From: Sarah Burrow <Sarah.Burrow@arun.gov.uk>
Sent: 08 June 2021 15:24
To: Planning.Responses <Planning.Responses@arun.gov.uk>
Cc: Maria Tomalova <Maria.Tomalova@arun.gov.uk>
Subject: RE: Planning Consultation on: BN/63/21/DOC

Engineers Comments Regarding Surface Water Drainage

Application No: BN/63/21/DOC
Registered: 17th May 2021
Site Address: Swallowfield Eastergate Lane Eastergate PO20 3SJ
Description of Works: Approval of details reserved by condition imposed under BN/121/19/PL relating to conditions 3-surface water drainage, 5-landscape scheme & 7-proposed drainage scheme for surface water.

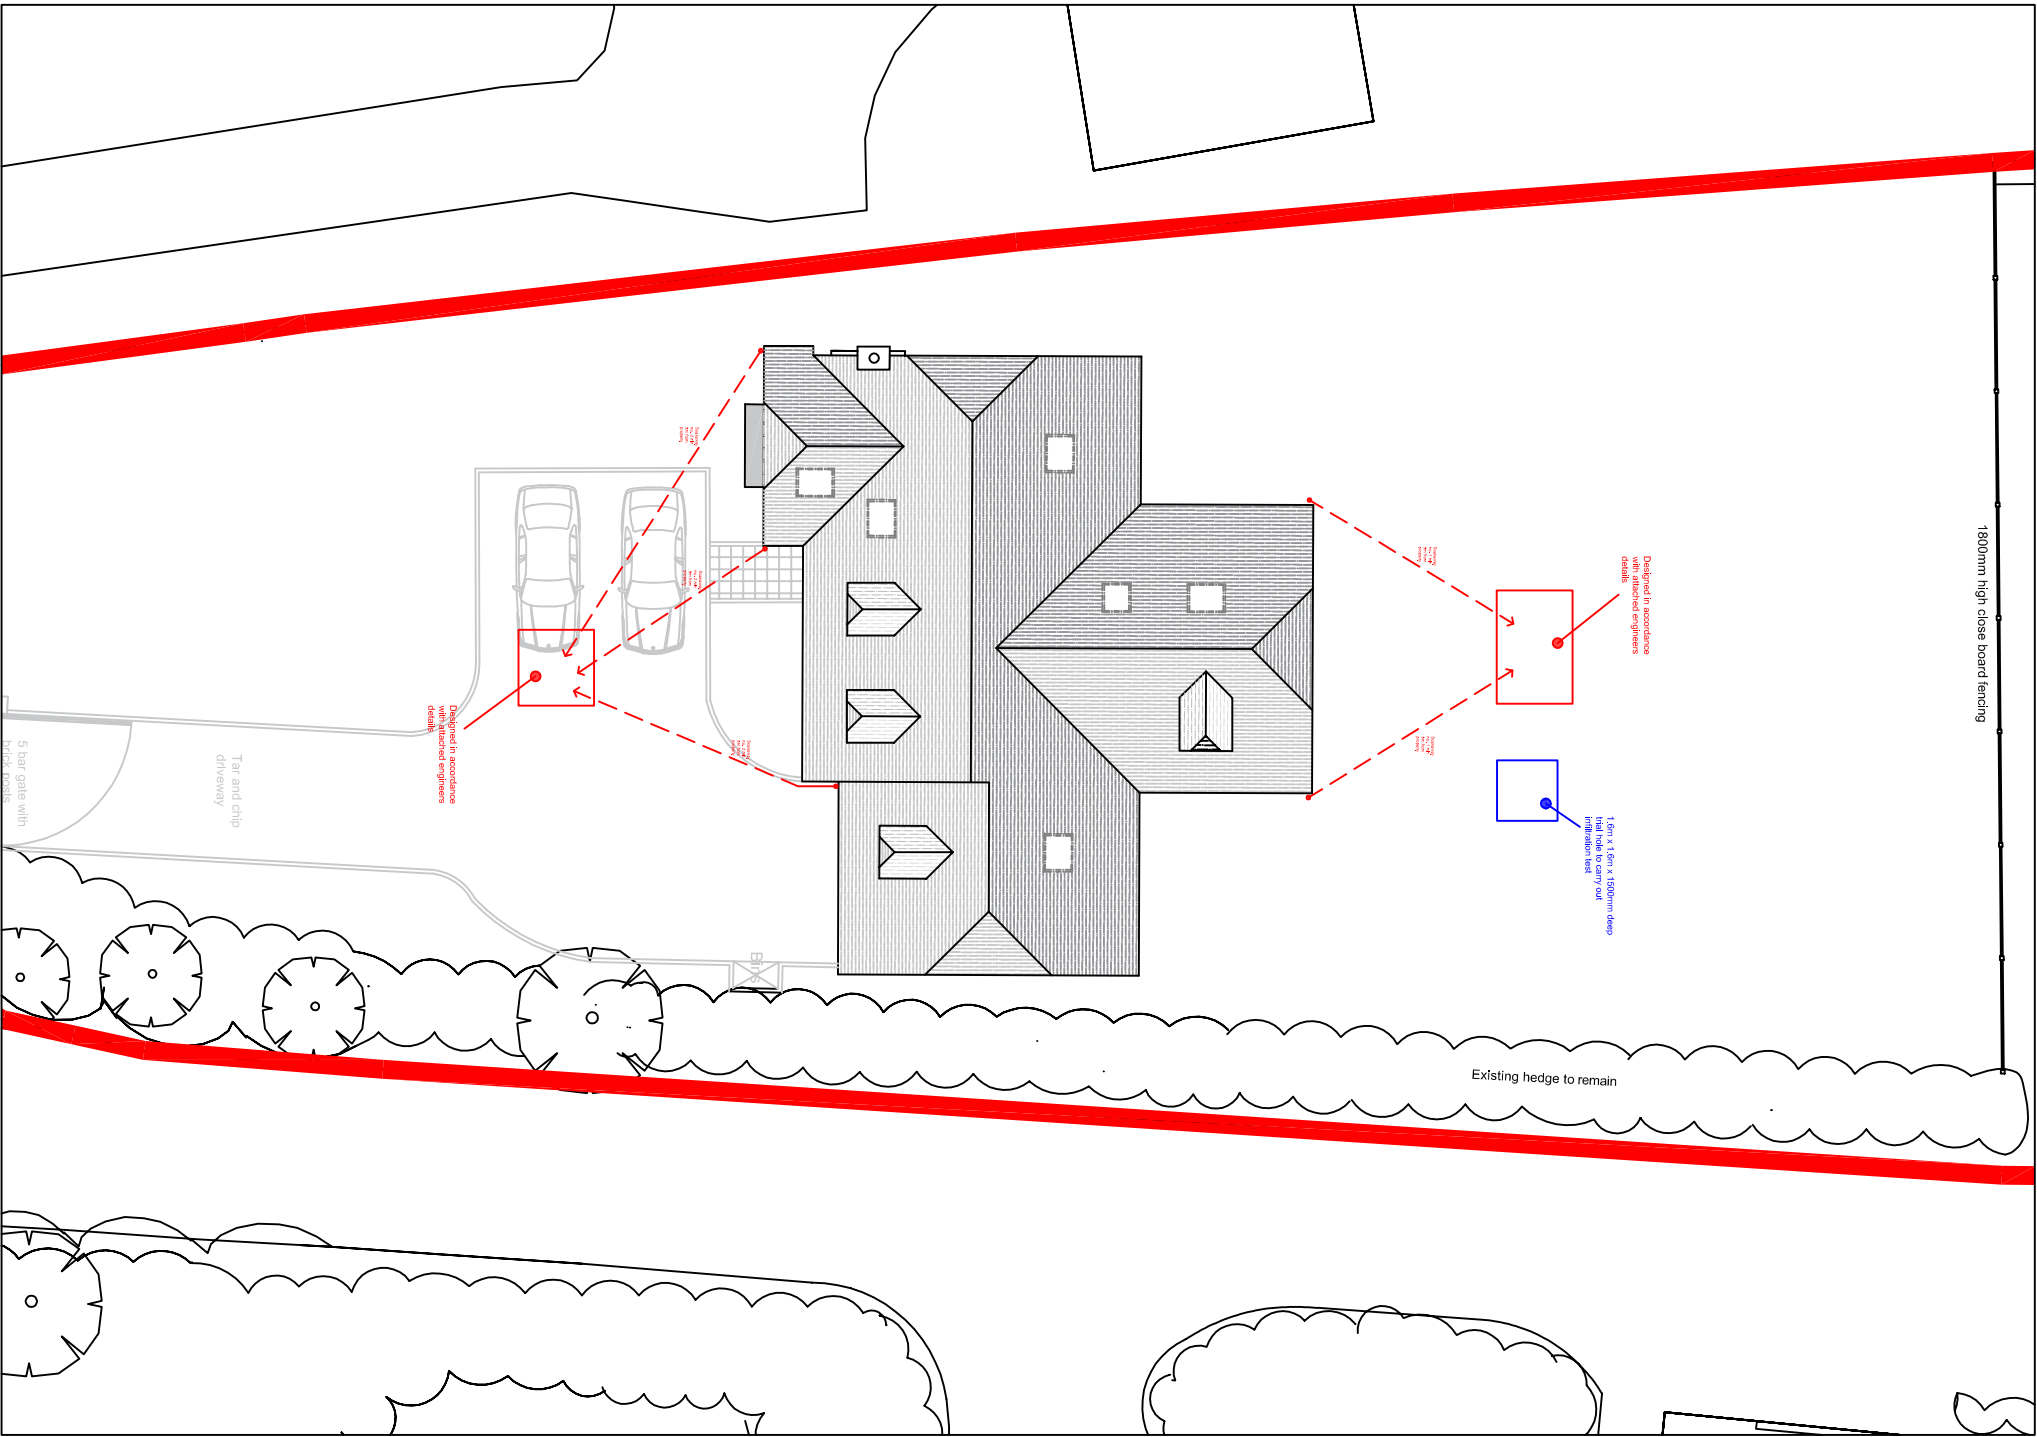
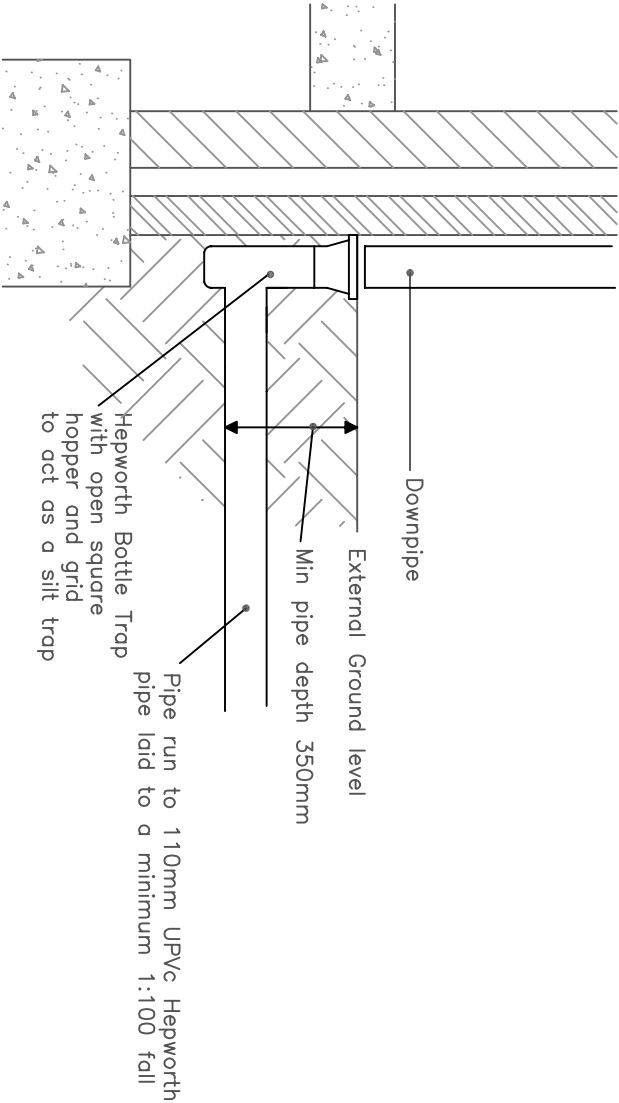
- Soakaway Layout and Details 59084/10 Rev A (within Microdrainage Soakaway Calculations document)
- Proposed Drainage 2019.257 Rev A (Showing bottle gully detail not included on the above)

DRAWING No. 59084 / 10	REV	A	CHECKED
	SCALE AS SHOWN	DATE APR 21	DRAWN JS
AutoCAD Ref: 59084-10.dwg

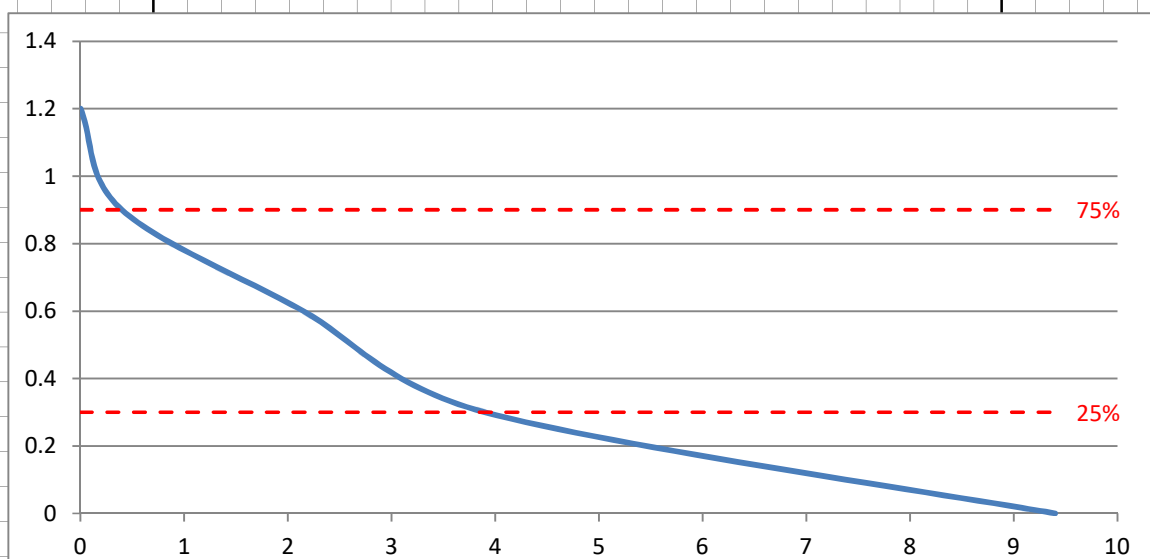
It is recommended that Condition 3 and Condition 7 are discharged. Surface water drainage should be constructed in accordance with the following plans:
